Your Ref: Y/74/17/RES

Our Ref: NW/ARU/17/34A

RE. Land at Kings Close Yapton BN18 0EX

Thank you for your correspondence of 15th November 2017, advising me of an Approval of reserved matters following outline consent Y/22/14/ for 1 No. 4 bed house, 13 No. 3 bed houses & 1 No. 2 bed flat over garages incorporating parking & access to main road via redefined alignment of Kings Close & highway improvement works at existing crossover for which you seek advice from a crime prevention viewpoint.

PLOT 1 HOUSE PLANS

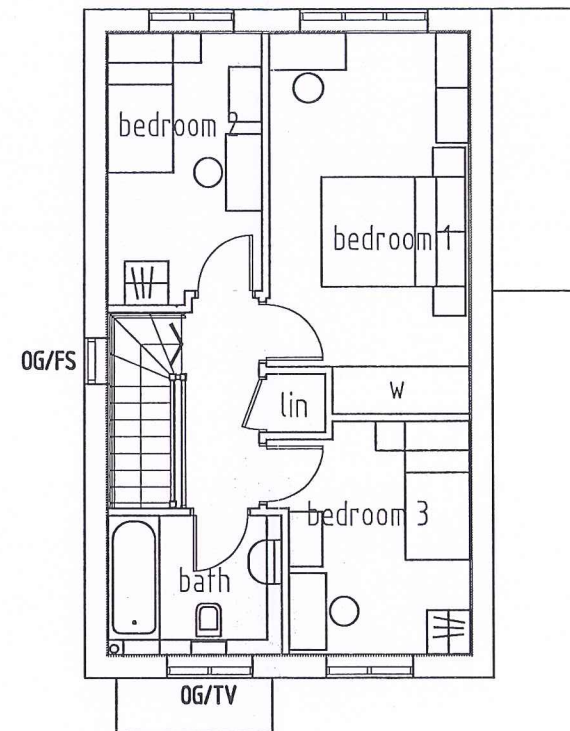
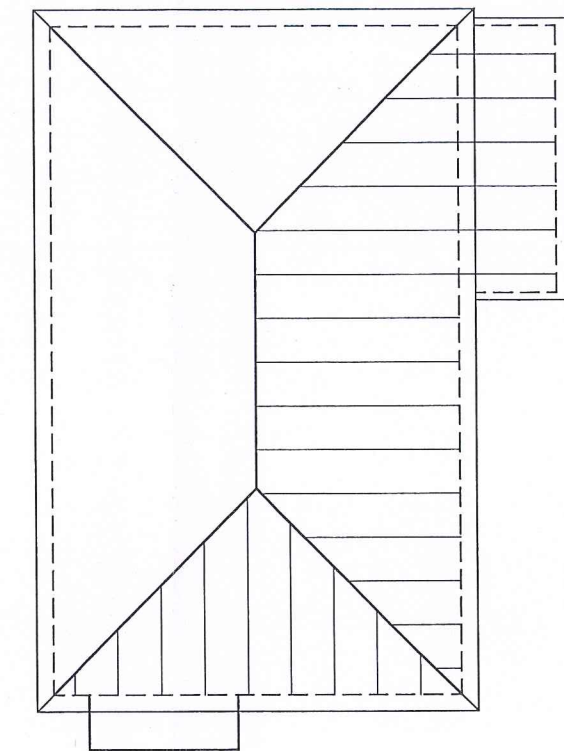
Plot 1GFL 6.450 must have its southern perimeter protected with 1.8m high fencing as above.
